**From:** [alan.story@hertfordshire.gov.uk](mailto:alan.story@hertfordshire.gov.uk)  
**To:** [Planning](#)  
**Subject:** Planning application 6/2016/0318/MAJ - Media House  
**Date:** 21 April 2016 09:39:03

**District ref:** 6/2016/0318/MAJ

Media House

Erection of additional floor to provide 1719 sq metres of B1a (Office) floorspace in association with the use of the premises for B1 offices together with elevational alterations to the remainder of the building

Drg.No: AT420-03

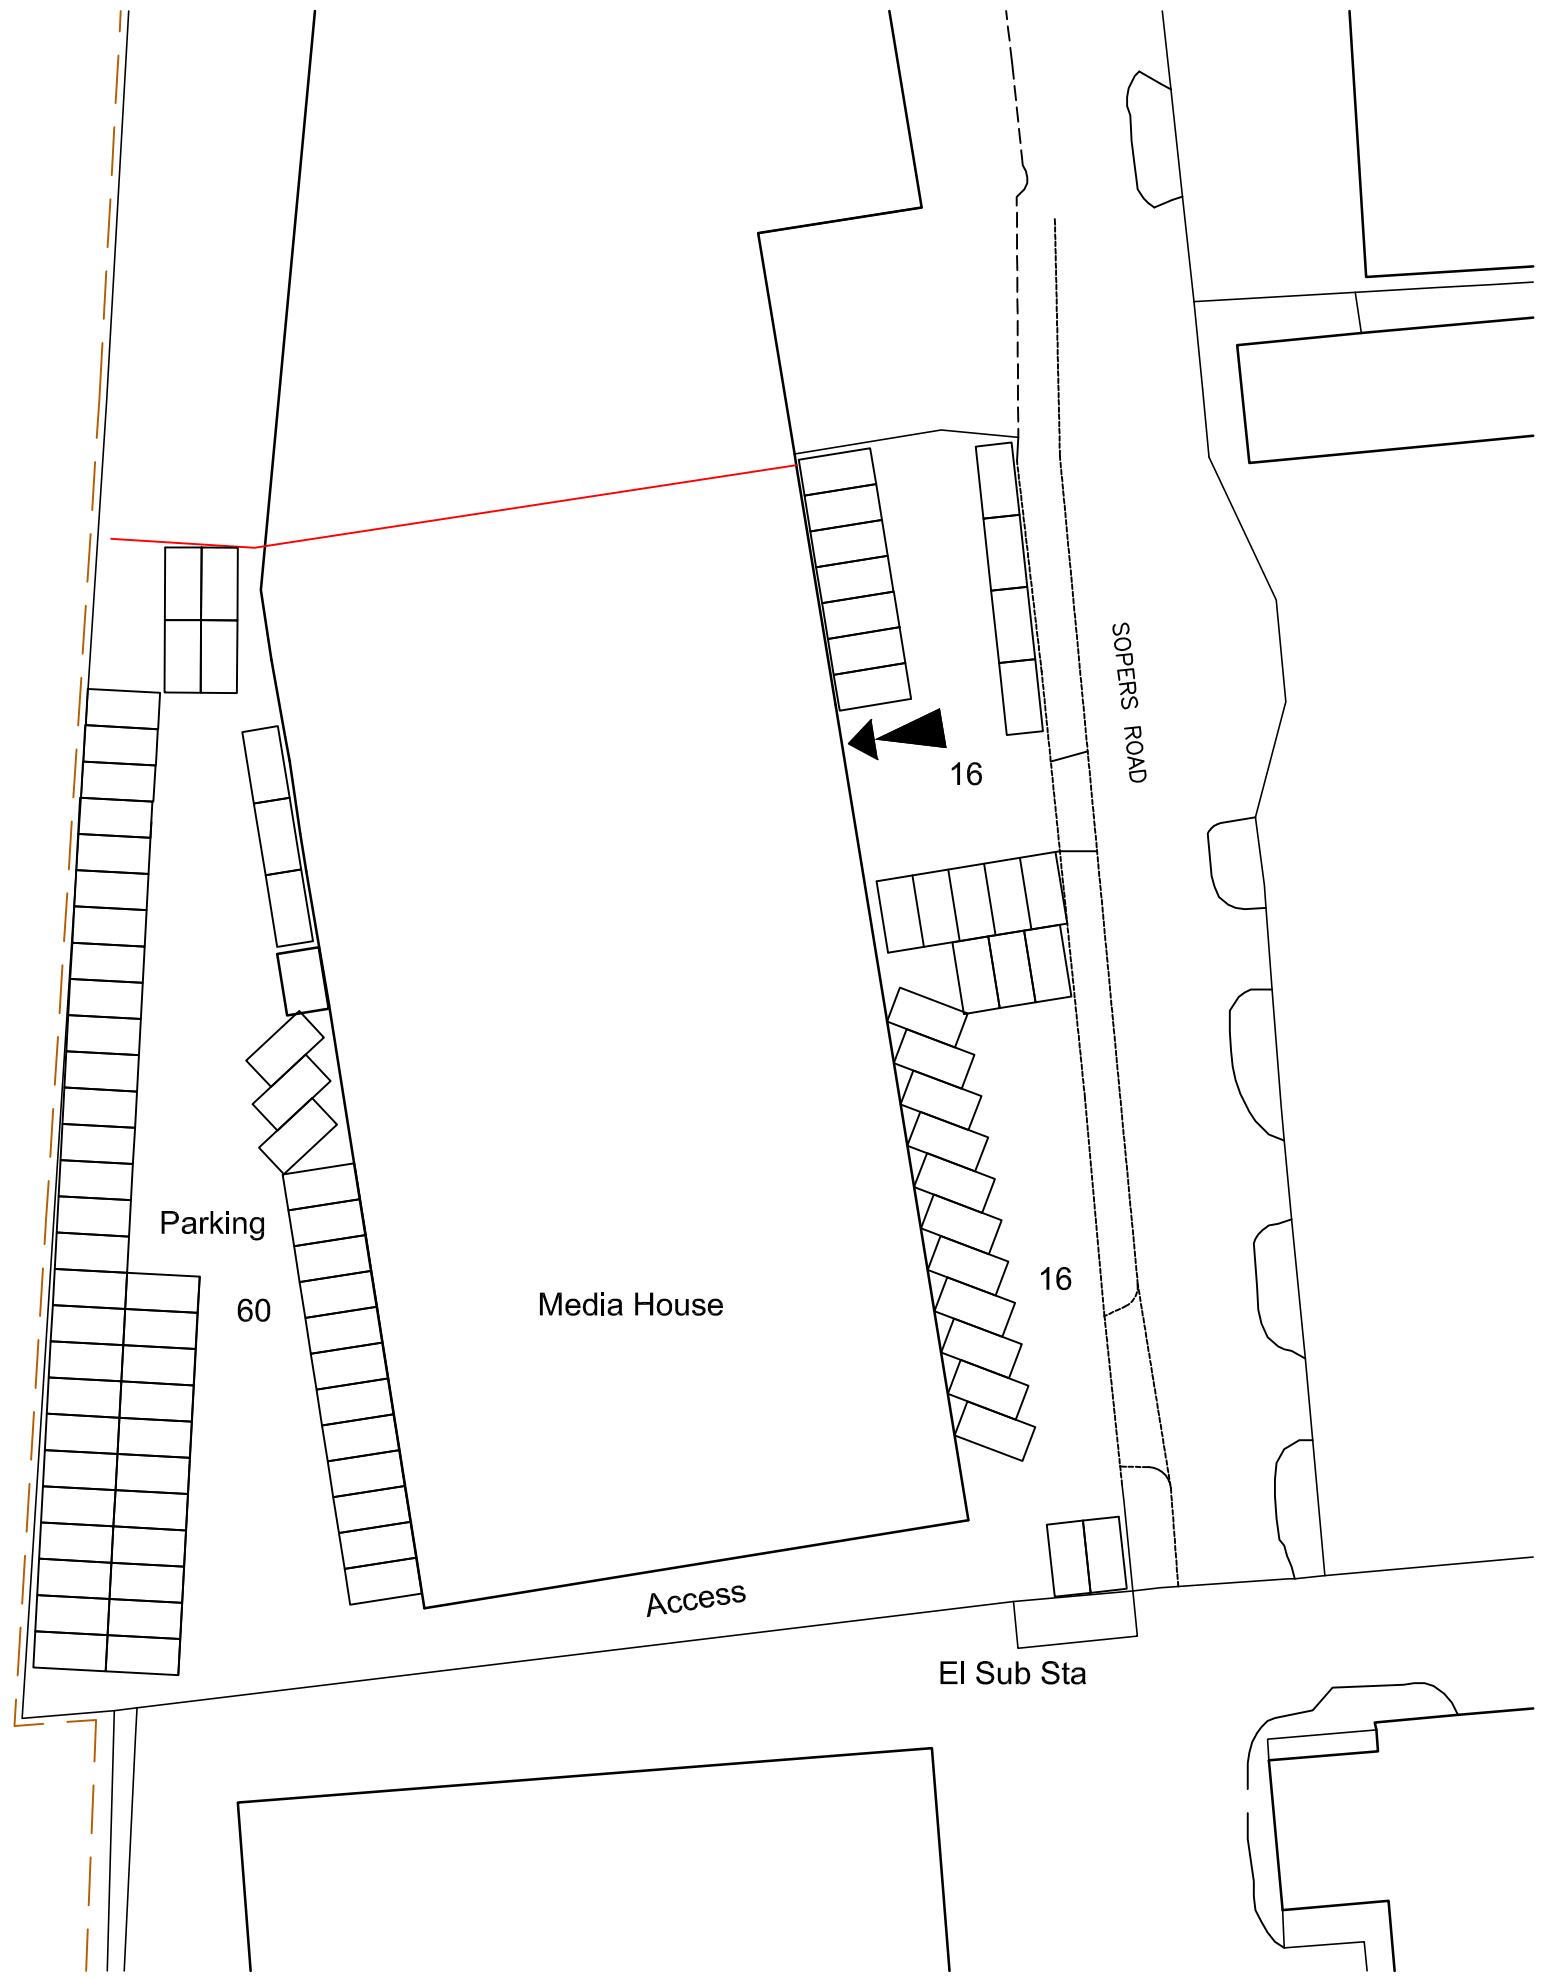
The application describes that parking for 92 vehicles shall be provided, and shall be for the LPA to determine whether sufficient parking is provided to serve the requirements of the increased employment space, however the Highway Authority note that in close proximity to the site is public car parking in the control of the Parish Council and parking controls exist locally (part) to control / deter parking in inappropriate locations. Any shortfall in parking is unlikely to have a significant highway impact.

I would observe that some parking is in tandem, but it is not unreasonable in a work environment for such an arrangement to be workable. Spaces parallel to direction of travel are shown at 2.4m x 4.8m and commonly a distance of 6m is recommended for such bays to ensure they're accessibility even when adjacent bays are occupied, but it is again not unreasonable to expect within an employment situation to consider this workable. Parking in such a situation can, at times, provide an informal arrangement, but I would recommend that all parking areas provided are identified with marked bays in order that the level of parking described shall be achieved representing effective use of site area. I present no objection that parking arrangement precludes through movement within the site, removing an access / egress arrangement and instead providing flows at both points of access, noting that footway activity is likely to be low.

No new or amended access is provided as part of the development, and existing access points (two off) are constructed to serve the industrial nature of the site providing wide vehicle crossovers at both points. As the development proposals include loss of B1(c) use (Light industrial) and the use becomes solely B1(a) offices, these accesses as presently provided are in excess of operational requirements. The Highway Authority would recommend that concurrent with any grant of consent, and prior to occupation, the access points be reduced in width to reflect the change in vehicle type attending the site. Such a requirement shall improve footway conditions at this point (as well as potentially provide additional on-street parking capacity)

Cycle parking is described as remaining at 10 spaces, it is unclear on submitted plans where this is located.

- 1) Prior to the commencement of the use hereby permitted the vehicular access shall be reduced in width to a maximum of 4.8m in accordance with the Hertfordshire County Council access construction specification Reason: In the interest of highway safety and traffic movement.
- 2) Prior to the commencement of the use hereby permitted the on-site car and cycle parking shall be laid out and demarcated, in accordance with the approved plan and retained thereafter available for that specific use. Reason: To ensure the permanent availability of the parking /manoeuvring area, in the interests of highway safety.
